**DEVIATION REVIEW
 AND DECISION FORM**

Address of Subject Property (Street Number/Name): Extension of Shawnee Drive north of Constitution Ave and west of Hannah Ridge Dr
 Tax Schedule ID(s) #: 5332316002
 Legal Description of Property: Tract GG Hannah Ridge at Feathergrass Filing No. 1
 Subdivision or Project Name: Hannah Ridge at Feathergrass Filing No. 4

Proposed Nature and Extent of Deviation: Allow crest K value of 8.3 and sag K value of 13.1 near at intersection of proposed Shawnee Drive at Constitution Ave.

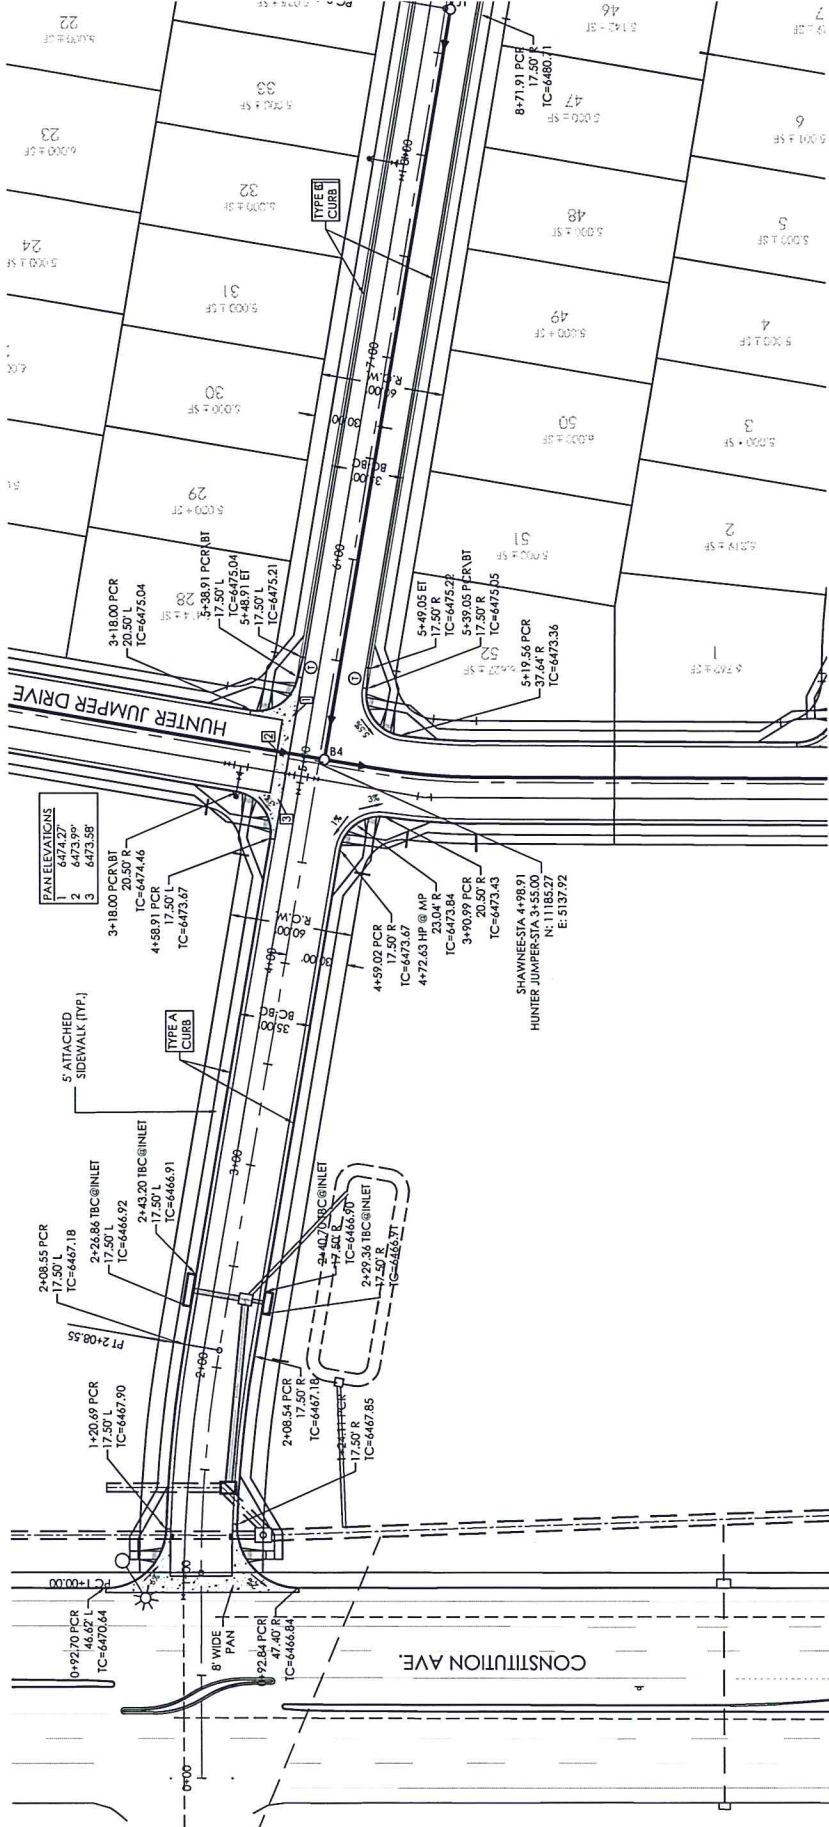
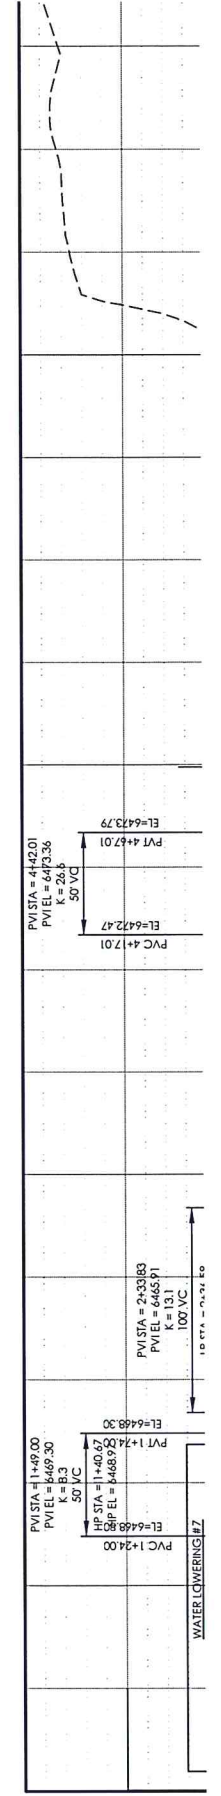
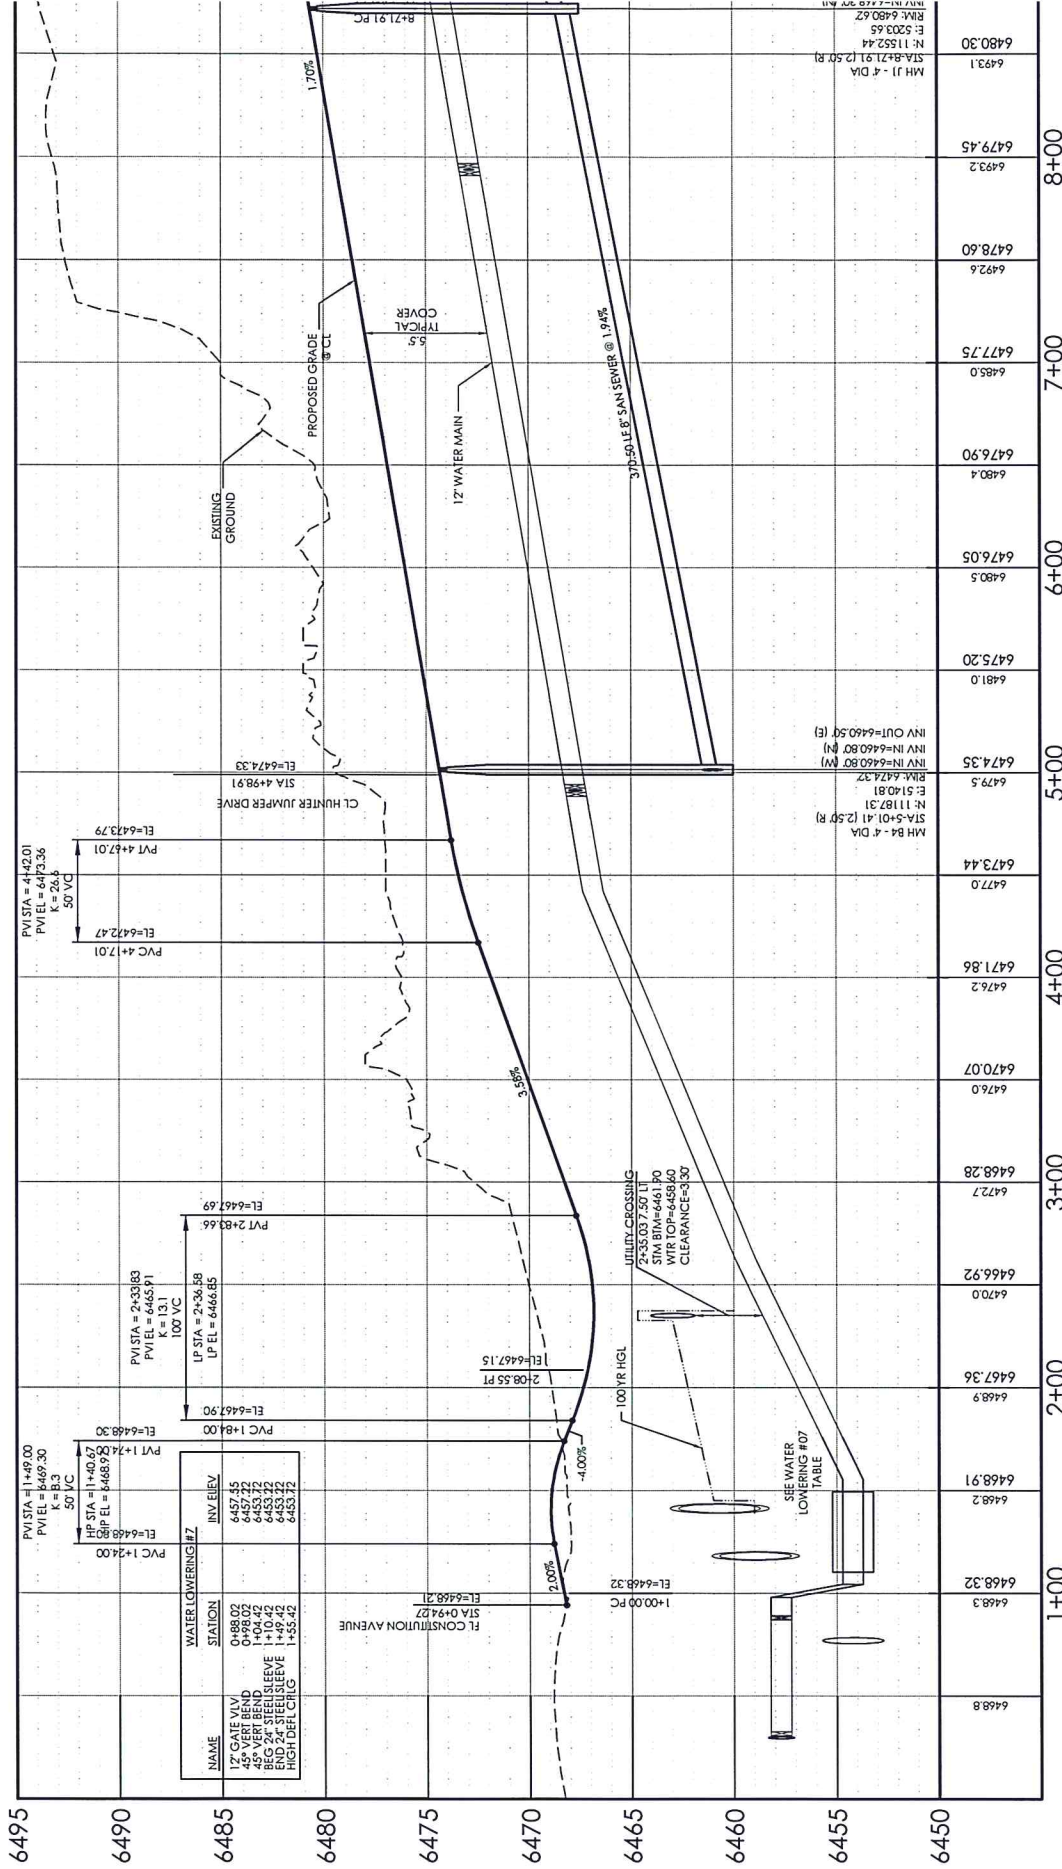
Reason for the Requested Deviation: There is a need to prevent storm drainage flows in Constitution Avenue from entering north into Shawnee Drive at the proposed intersection. Therefore the grade of Shawnee Drive is raised from the existing Constitution Ave. curb line as the street proceeds north. In addition, it is necessary to create a low point for sump drainage collection at a point just north of Constitution Ave to prevent flows from the Hannah Ridge site from entering Constitution Avenue. The proposed elevations in Shawnee Drive and Hunter Jumper Drive allow proper grades in the adjacent part of the site to function properly for access, drainage and utilities. It will not be possible to lengthen the vertical curves further without affecting desired roadway grades and compliance with drainage requirements.

This section of Shawnee Drive is 400 feet long between Constitution Avenue and Hunter Jumper Drive with stop signs at both ends. The roadway is a local roadway with design and posted speed of 25 miles per hour. The length of this section of road is short enough that speeds typical on non-residential collectors will not be present. The vertical curves are immediately adjacent to the stop controlled Constitution Avenue intersection. The resulting elevations will not result in lack of visibility of cars or other objects in the roadway with elevation difference between the two vertical curves of about 2 feet in a distance of about 96 feet.

Comparison of Proposed Deviation to ECM Standard: The request is to allow crest K value of 8.3 and sag K value of 13.1 in proposed Shawnee Drive near Constitution avenue where crest K value of 12 and sag K value of 26 at 25 mph design and posted speed is required.

<h1 style="margin: 0;">Approved</h1>  <p>By: Jennifer Irvine, County Engineer Date: 03/07/2018</p> <p style="font-size: small;">El Paso County Department of Public Works</p>
--

Review and Recommendation:
APPROVED by the ECM Administrator
